**Principal Areas of Disagreement Summary Statement (PADSS) from National Highways Limited (“National Highways”)**

**Application by Gloucestershire County Council (“Applicant”) for an Order Granting Development Consent for the M5 Junction 10 Improvement Scheme (“Scheme”)**

**Planning Inspectorate Reference Number: TR010063**

Submitted at: Deadline 3 - 30 July 2024

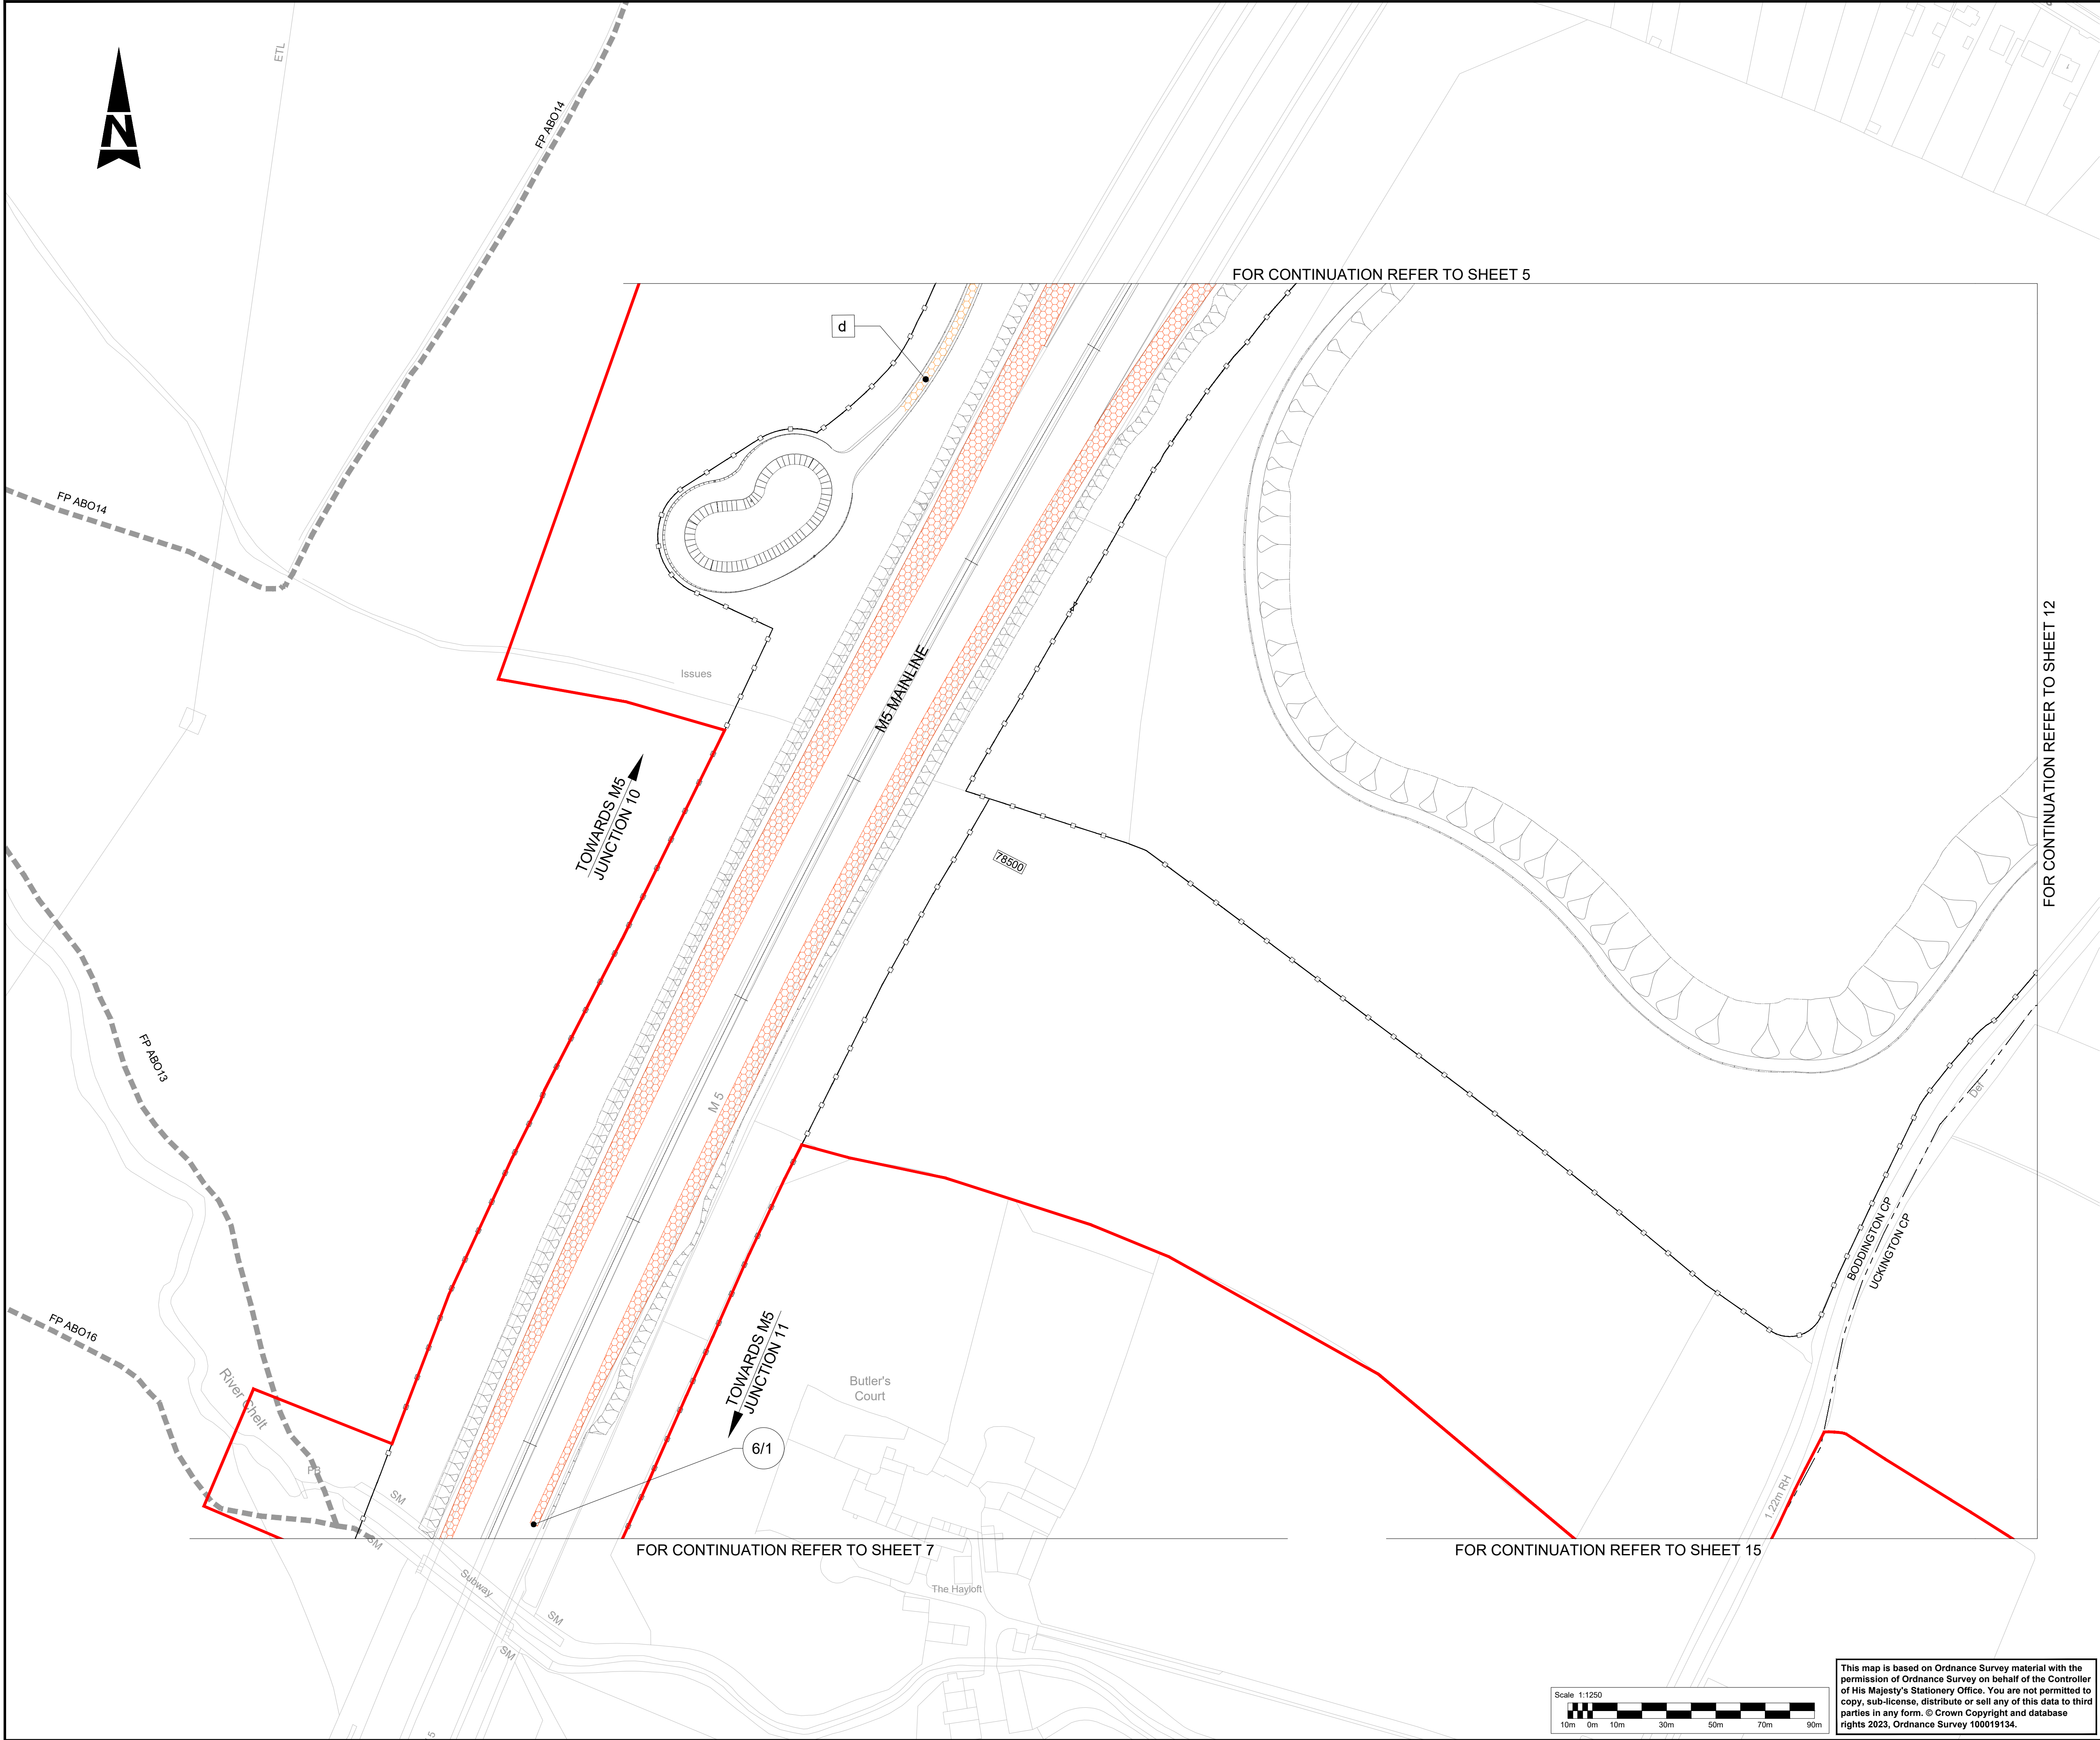
31.				Resolved – Agreed matter moved to SoCG
32.	Design	Omission of a viewport to show stopping up on sheet 5 of 16 of Street, Right of Way and Access Plans	National Highways requests that an insert to the drawings is added to show the stopping up of the old N/B on slip road under the junction overbridge.	High
